Recommendation Report for Planning Permission for Works or Extension to a Dwelling

REF NO: LU/128/12/

LOCATION: 92 Greenfields
Littlehampton

PROPOSAL: Two storey side extension Resubmission of LU/56/12

EAST ELEVATION
PROPOSED ELEVATIONS

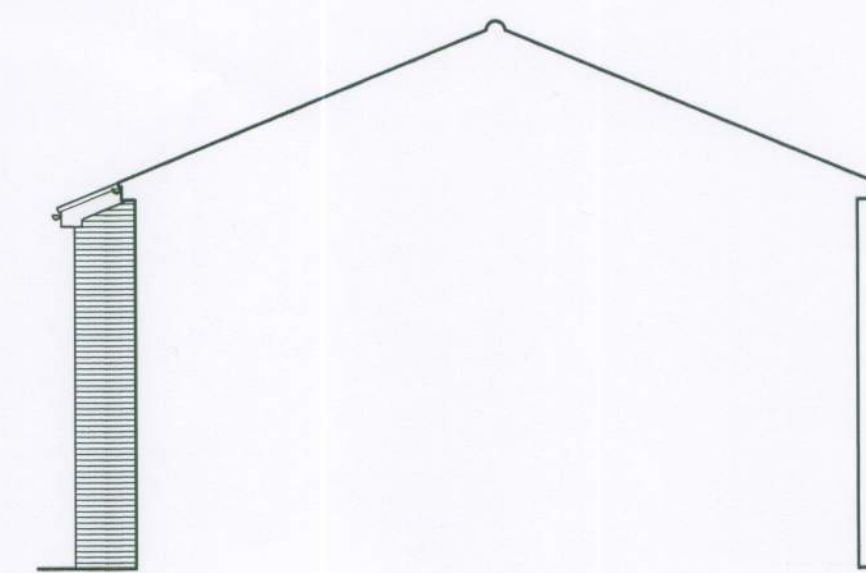
The revised scheme has set the extension back further from the road, allowing a sense of space to be retained to the front. The height is also stepped down from that of the original dwelling and this, combined with the extension being set back from the frontage, is considered to result in a structure that will maintain visual subservience towards the original dwelling. Further, by breaking up the roof line, it is considered that the potential for monotony in the appearance of the extended frontage has been counteracted, whilst the gable ended appearance remains harmonious towards the overall appearance of the dwelling.

- 4 The first floor en-suite window on the eastern elevation of the extension shall at all times be glazed with obscured glass. It shall also be fixed to be permanently non-opening other than where it is a minimum of 1.7 metres above finished floor level.

PROPOSED FIRST FLOOR PLAN

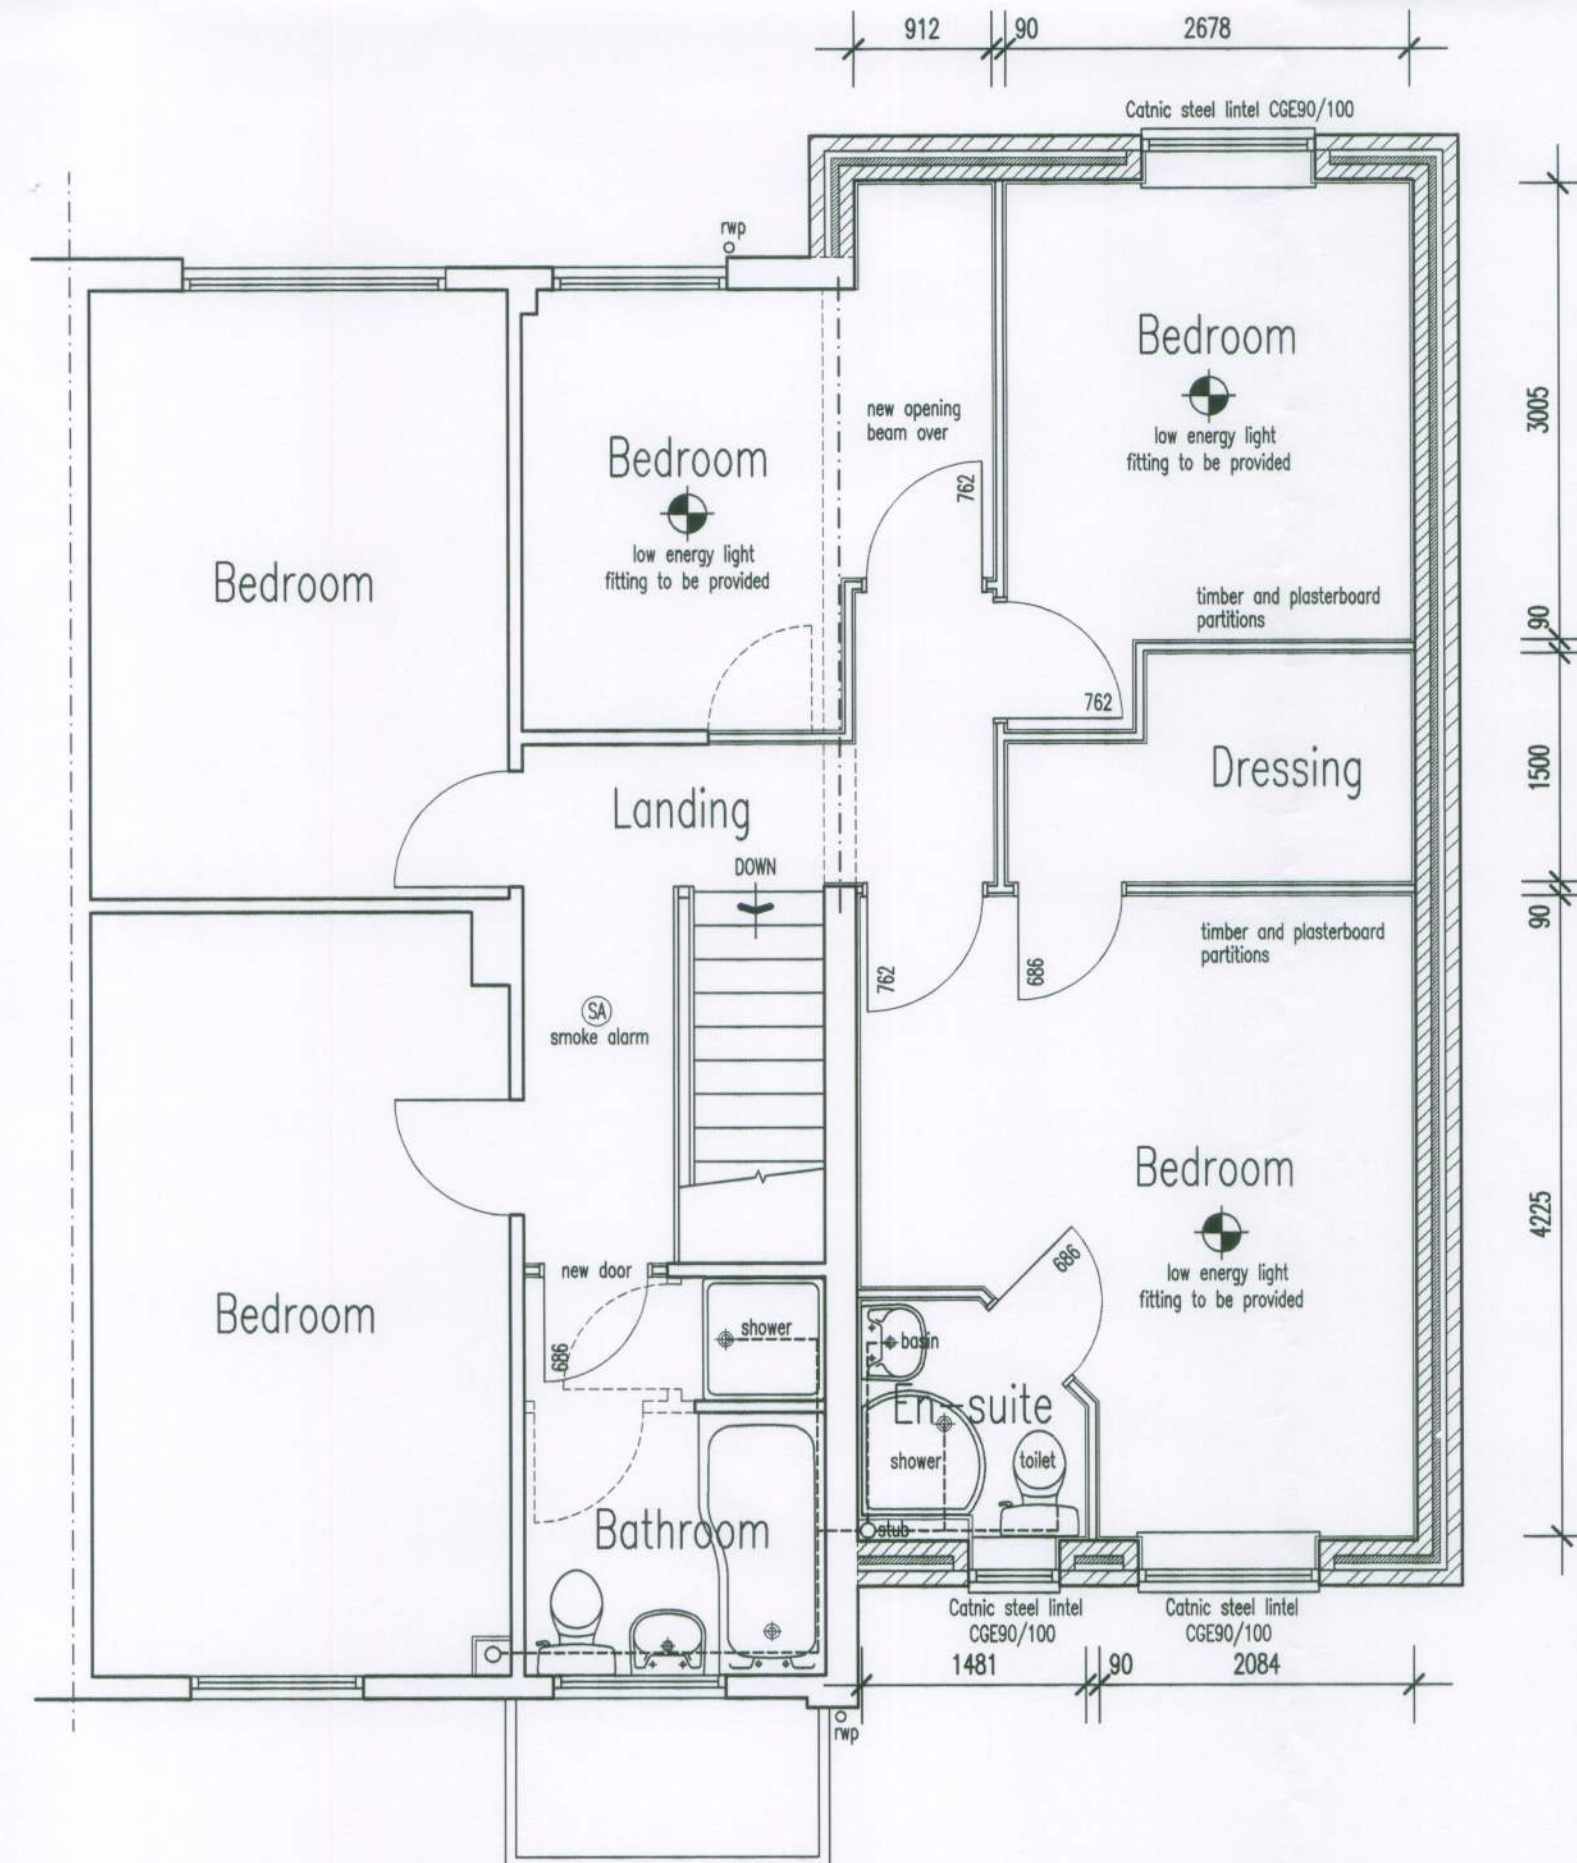
No concerns regarding residential amenities were raised within the previous application due to the positioning of the proposed extension well away from boundaries shared with neighbouring residential properties, this is also the case with the revised scheme. It is noted that there is a first floor window serving an en-suite bathroom overlooking the road and it is considered prudent to attach a condition regarding this window to be obscure glazed in the interests of privacy.
